**Consultation Response from KC,
Lead Local Flood Authority**
2021/93567 Land off, Westgate, Cleckheaton, BD19 5DR
Erection of 194 dwellings with associated works
**Date Responded: 28th
November 2021**
**Responding Officer: Paul
Farndale**
Responding Ref:
Summary

Figure 1 - Environment Agency's Flood Map for Planning

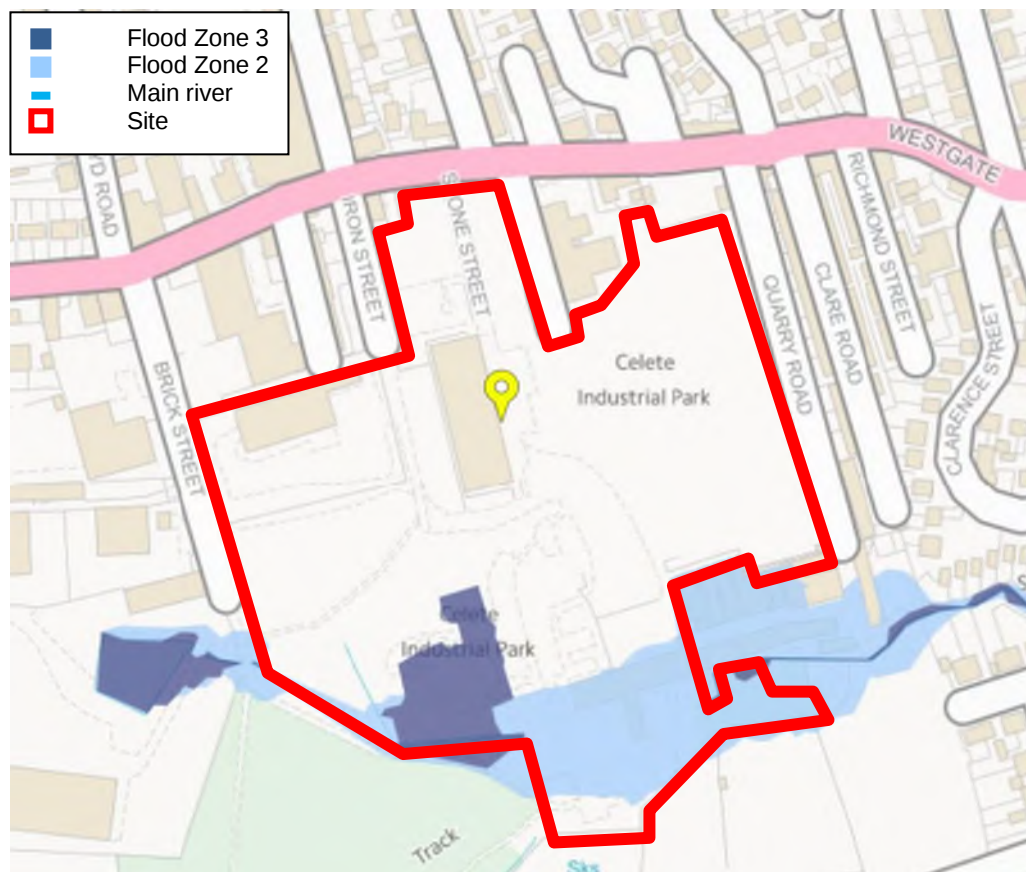
- Proposed housing is located in SFRA flood zone 3ai and is not compliant with Kirklees Local Plan Policy. This is an avoidance tool to prevent developments in areas that would be classed as functional flood plain but a previous development has been located here. It is not Kirklees policy to allow risk mitigation in such areas, e.g., altering levels to suit, and is an outright rejection.
- Storage tanks placed in flood zones are vulnerable to being inundated from river flooding and therefore will not operate as designed.

Drawing: PLANNING LAYOUT

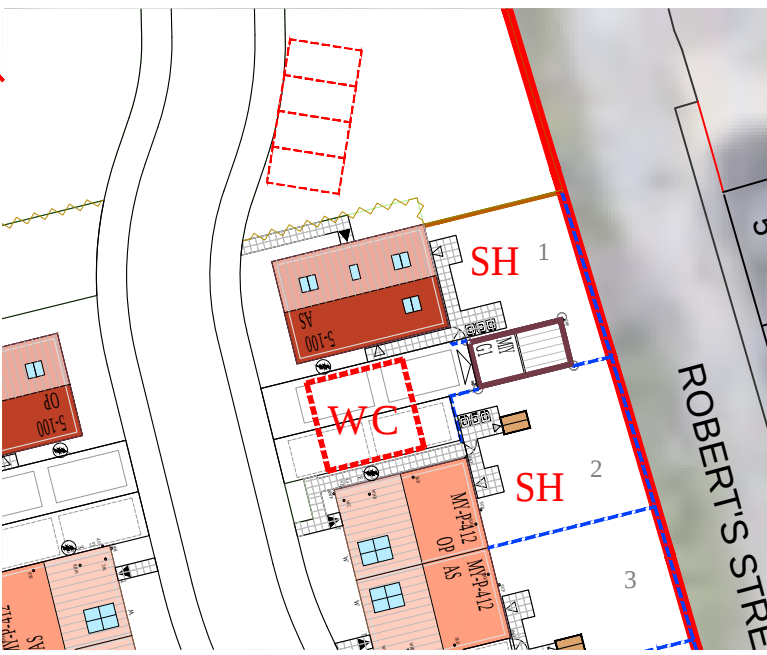
This response provides a correction to our previous consultation response. After a re-examination of the flood zones we can see that the applicant has produced a layout that fits a 'sequential approach', i.e. all houses are positioned in flood zone 1.

However, given the regularity of flooding of SFRA zone 3ai, it would be unwise to position an attenuation tank here and we believe river flooding will diminish its value to surface water risk management as it will be regularly inundated from another source.

A discussion to fix the discharge rate and therefore determine the volume of attenuation is therefore critical in the decision of layout as the tank will need to be relocated. We estimate to avoid double counting of preserved landscaped areas, that a greenfield discharge restriction of 25l/s is appropriate for this site.

Surface water flood routing for the 1 in 100 event includes a through route via Iron Street. This is mentioned in the FRA and layout design and levels should clearly demonstrate that this route is maintained post development and avoids curtilage by using proposed roads and open space only.

Flood routing. The road network on site and open space should be designed so flooding routing avoids property curtilage in blockage scenarios and exceedance events. There should be no basin features

causing standing water where reasonably practicable. We believe this site has the capacity to ensure the above.
